PLANNING CONSULTATION RESPONSE

Application No	2026/0362
Address	4 Hazelwood S71 2GE
Date of Consultation Reply	04.06.2026
Name	Cllr Brandon Green

I wish to object to the above retrospective planning application due to the significant impact I believe this development is having on the amenity of neighbouring residents, particularly the occupants of No. 6 Hazelwood.

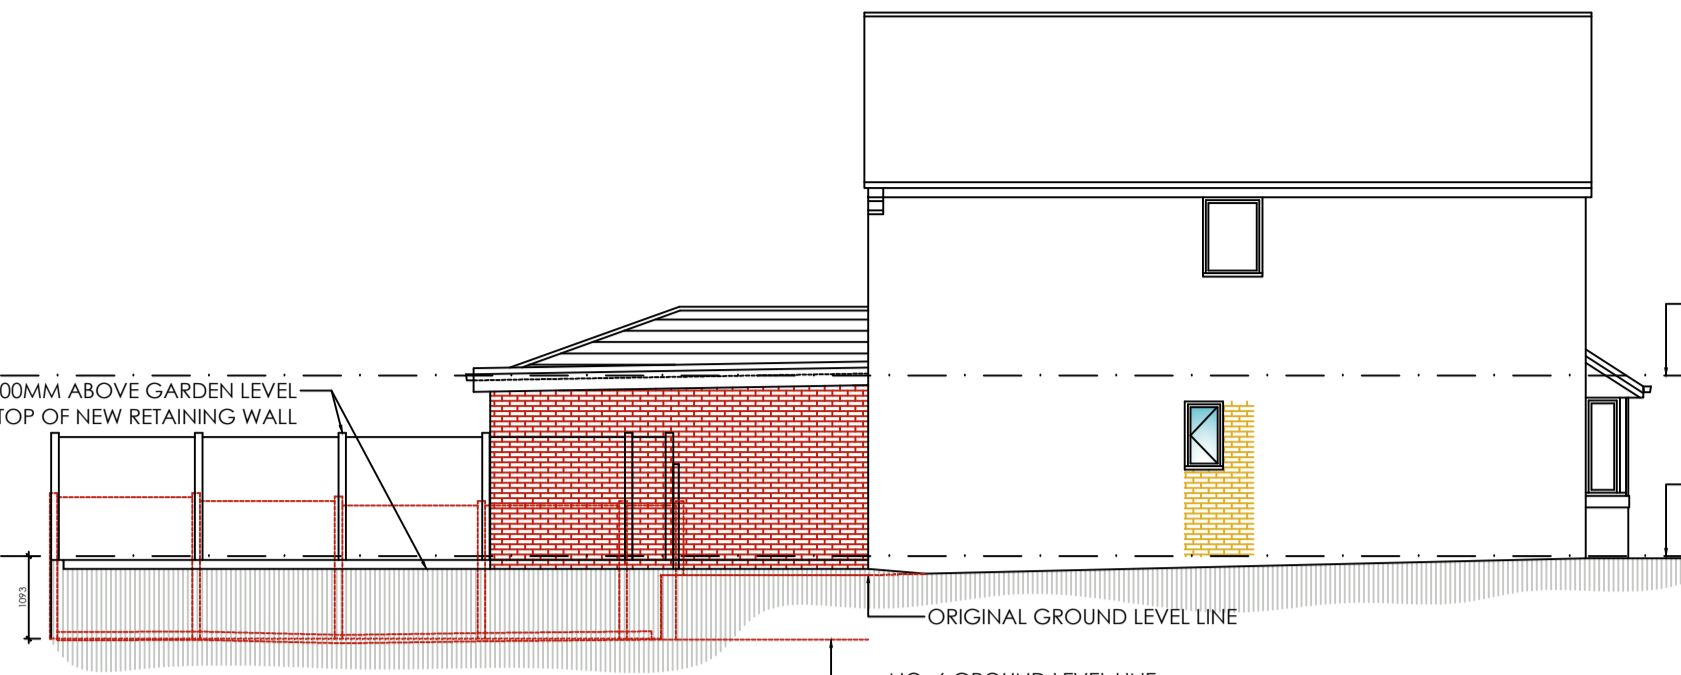
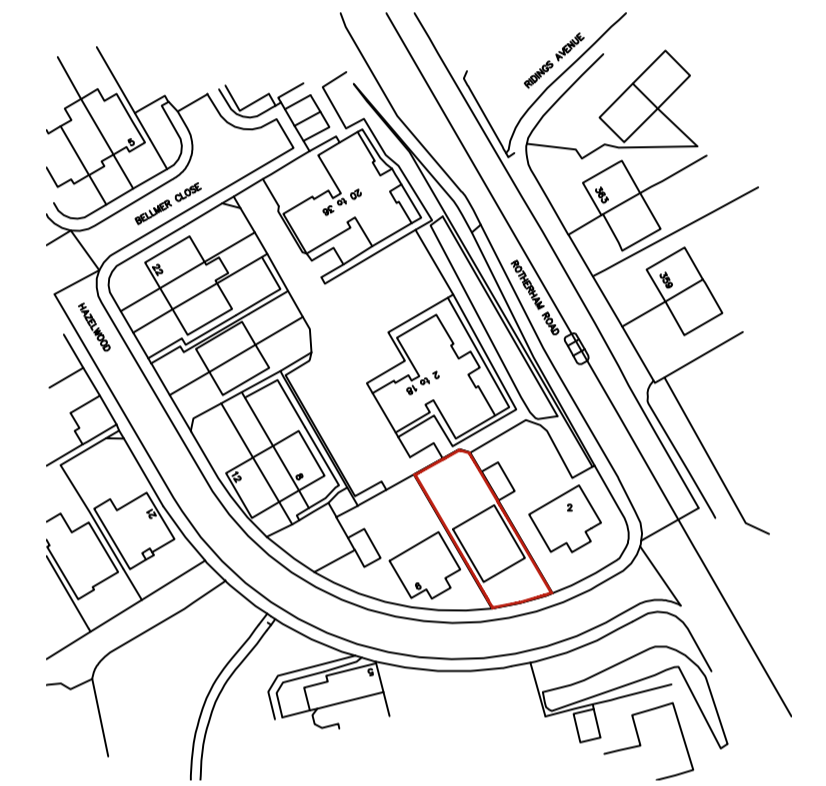
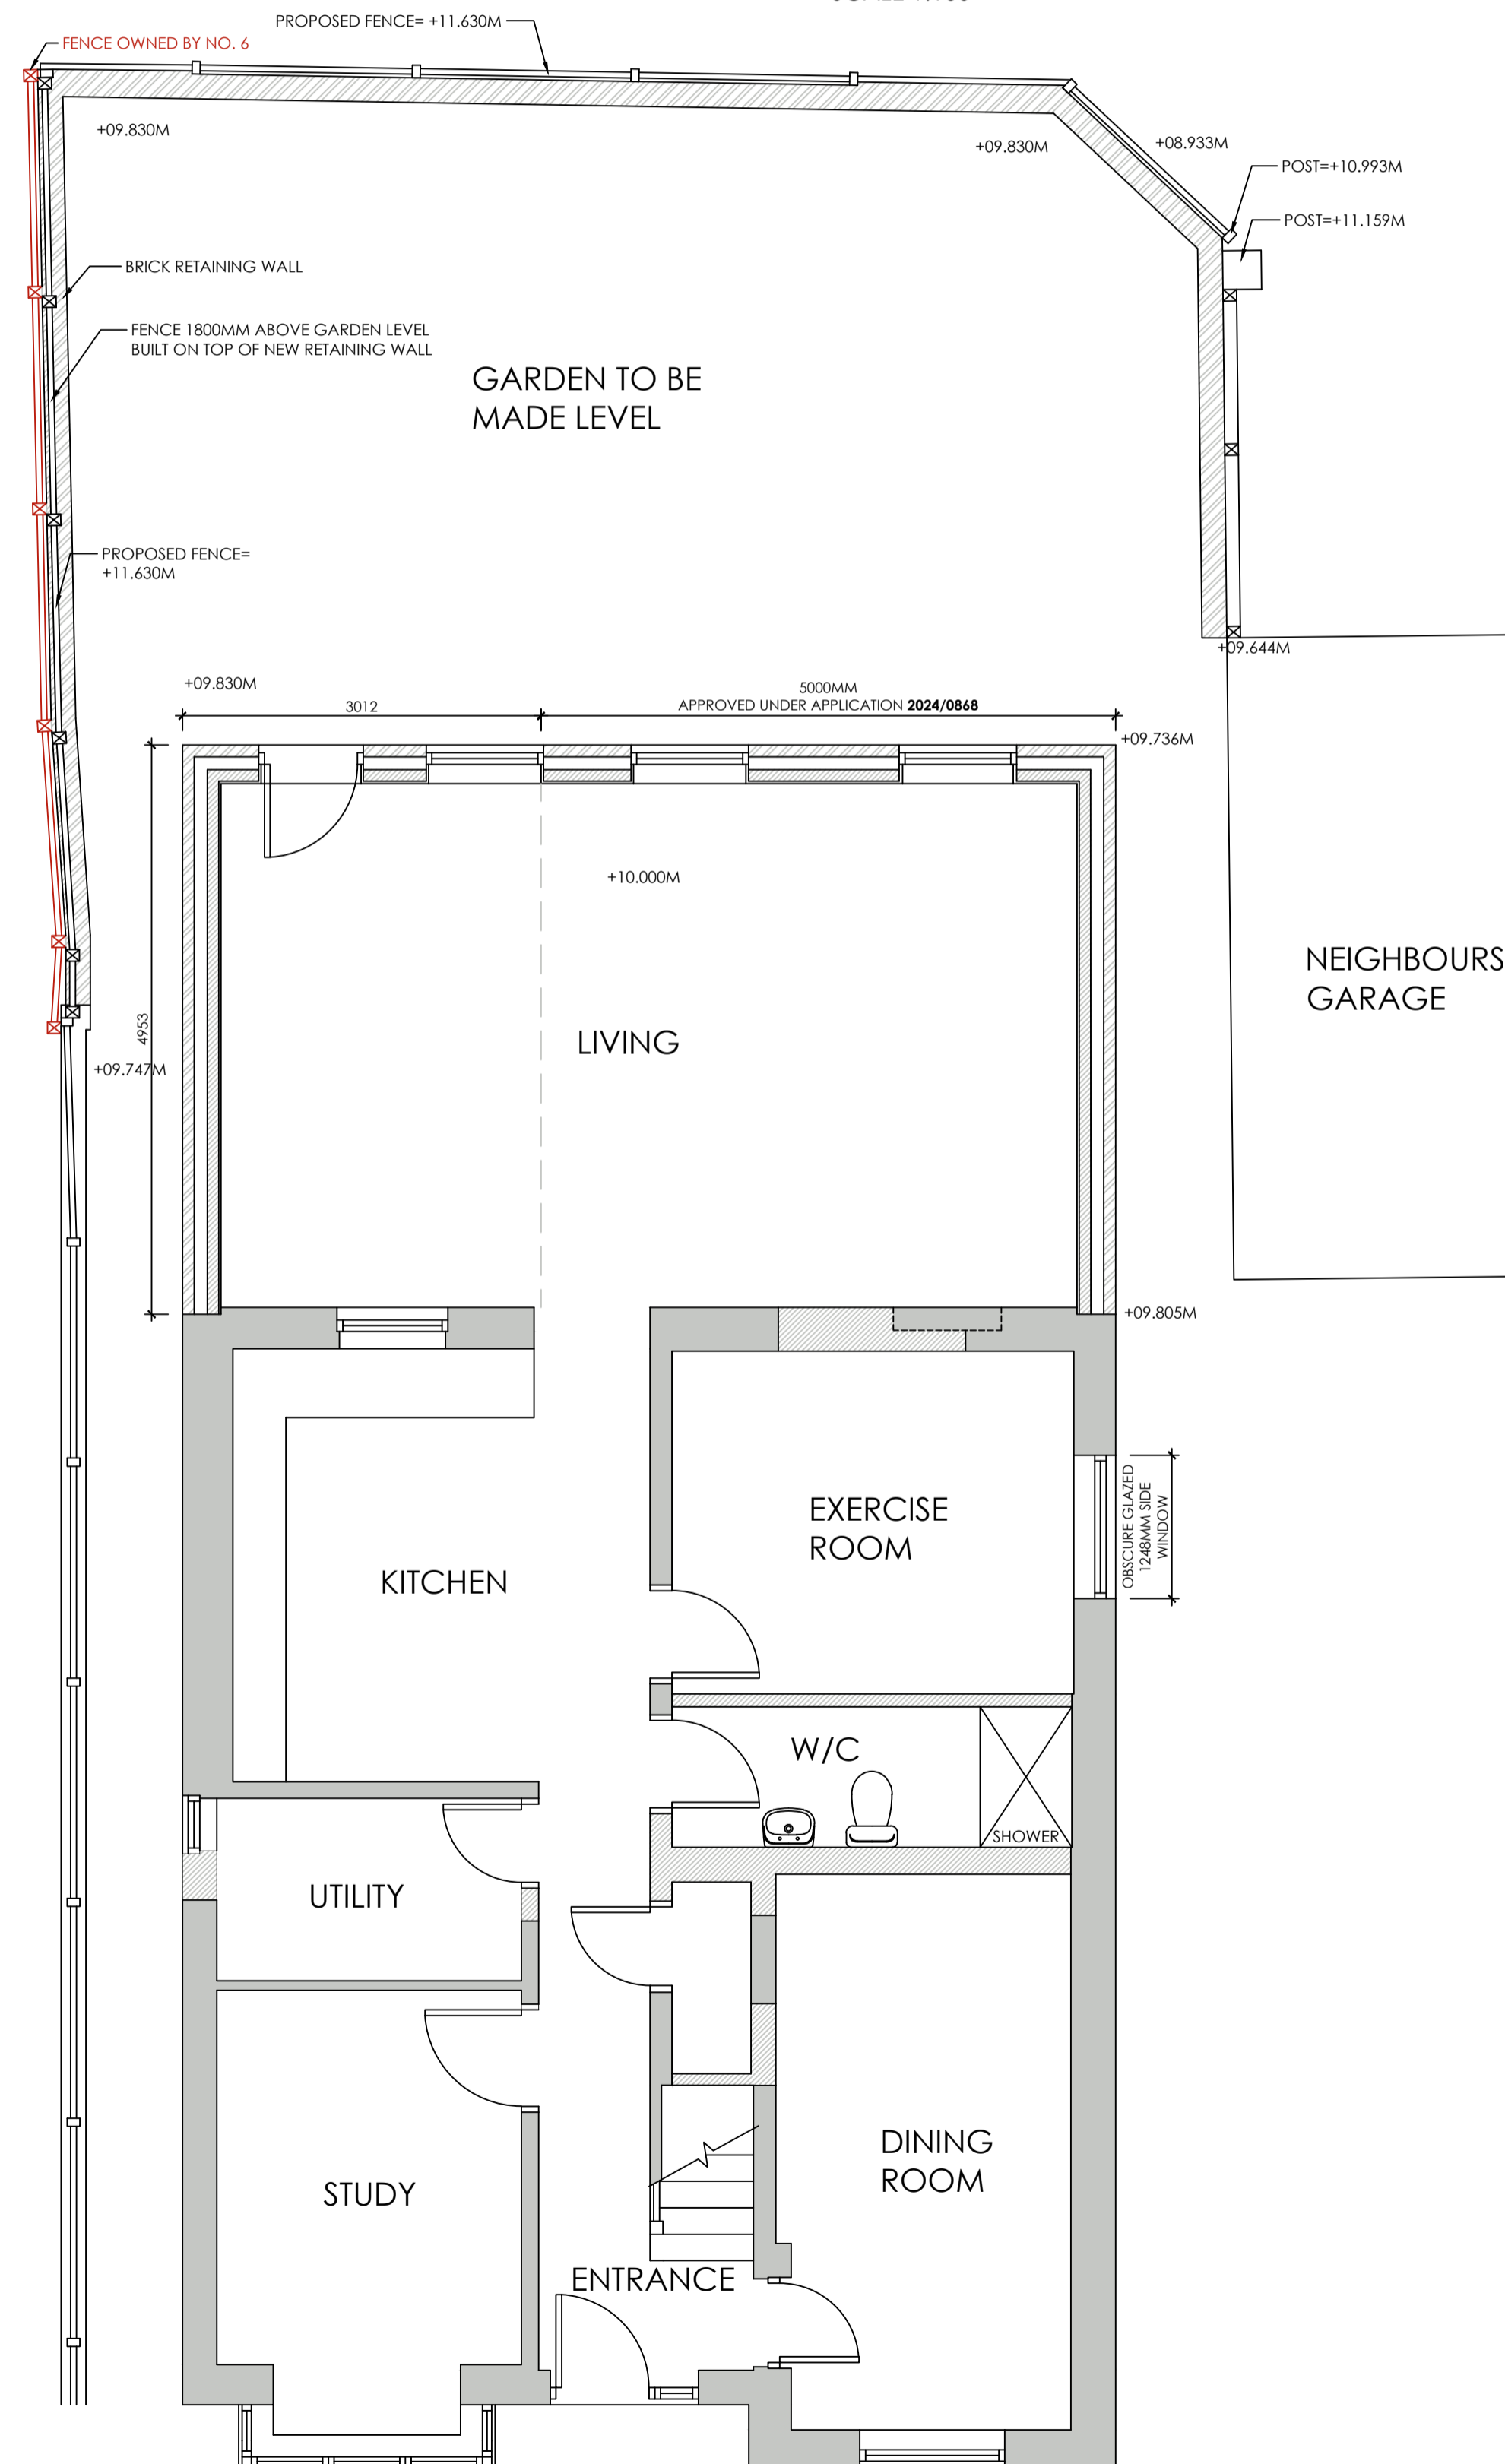
My principal concern is the impact on the neighbouring property. The extension is located extremely close to the boundary with No. 6 and appears to have reduced the amount of natural daylight reaching the neighbour's home and garden. Residents have described a noticeable loss of light and an increased sense of enclosure since the works began.

I am also concerned about the effect the development is having, and may continue to have, on the neighbour's privacy. A large mound of rubble and construction material remains within the garden. My understanding is that there are proposals to level this area and surface it. However, if the finished ground level remains significantly higher than the neighbouring garden, it could create opportunities for overlooking into the adjoining property. Concerns have already been raised that individuals standing on the raised area have been able to see directly into the neighbour's living room.

In addition, residents have expressed concerns regarding potential surface water run-off from the raised ground level during periods of heavy rainfall, and whether works undertaken adjacent to the boundary may have implications for the neighbouring property's damp-proof course.
